Barnsley Metropolitan Council

Application Reference: 2026/0548

Site: Carlton Park, Church Street, Carlton, Barnsley, S71 3HG

Proposal: Renovation of existing sports pavilion, including the demolition of existing sports hall and erection of new single storey activity hall, new external terrace and steps.

site layout : proposed

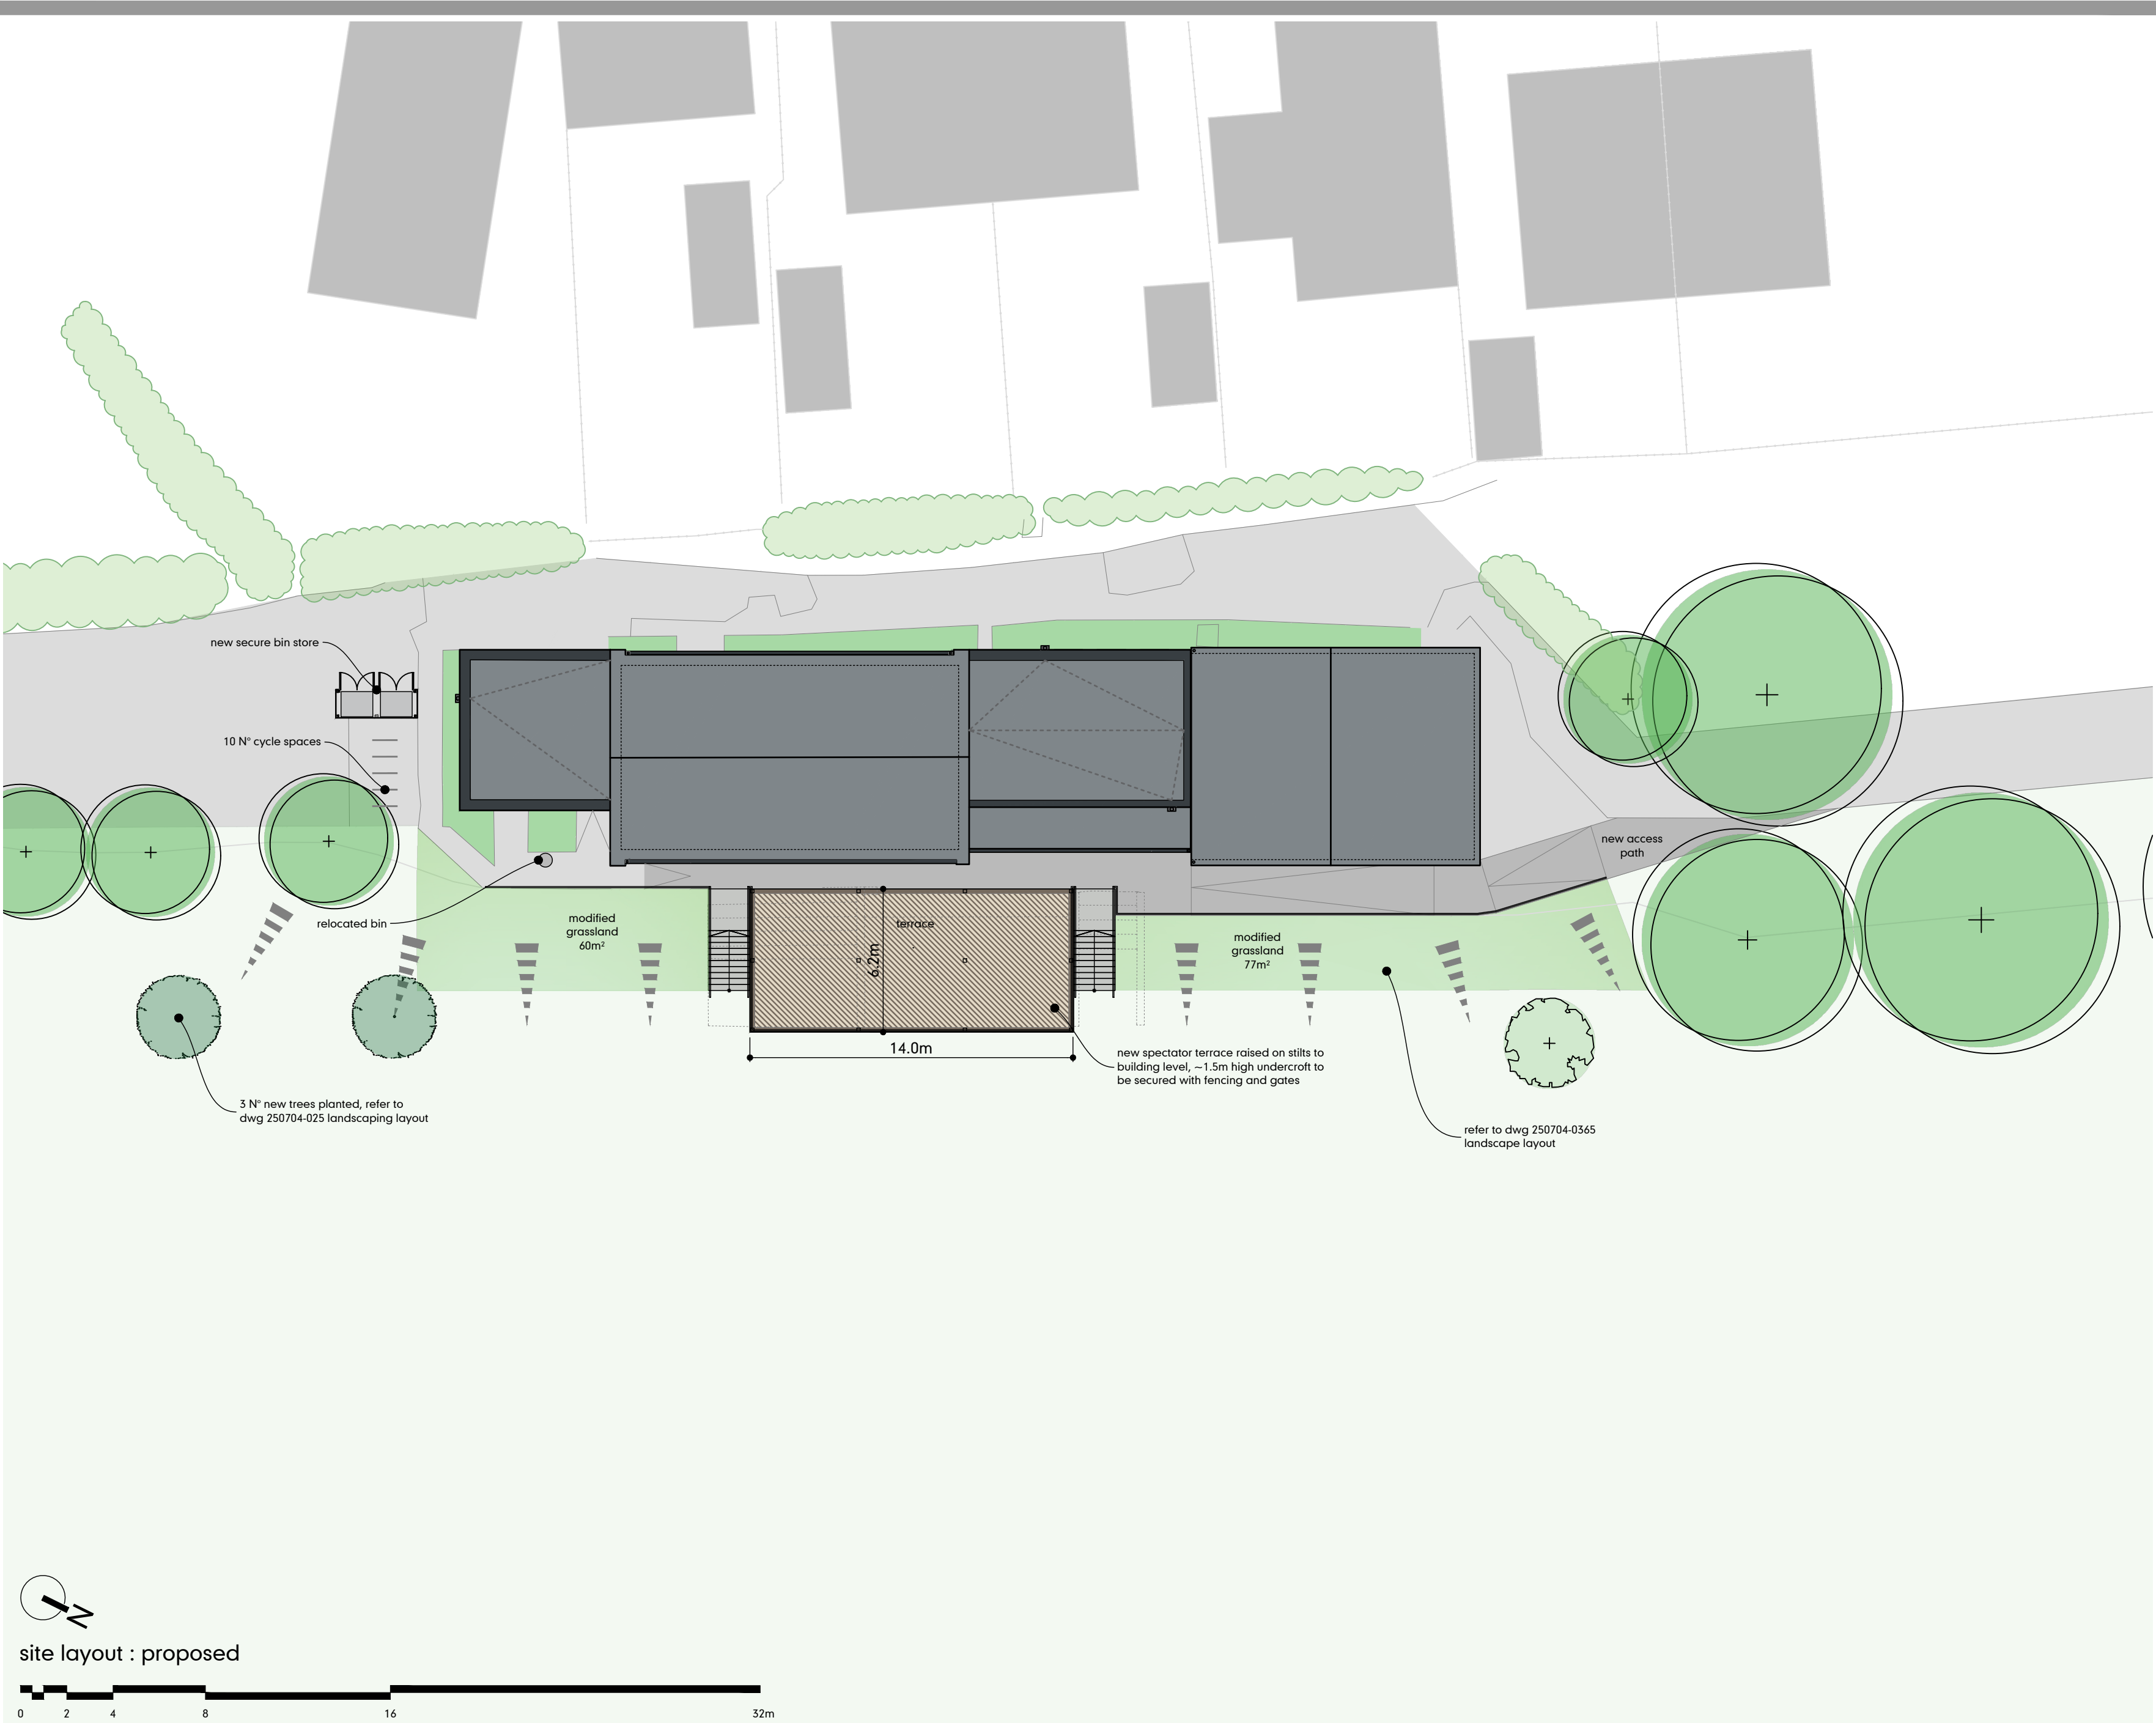
Clear site plans showing the proposed spectator stand and associated landscaping measures in relation to the sports pitches and their safety run-off areas have not been provided. However, Sport England is satisfied that the development would not adversely affect the provision or use of the playing field's sports pitches.
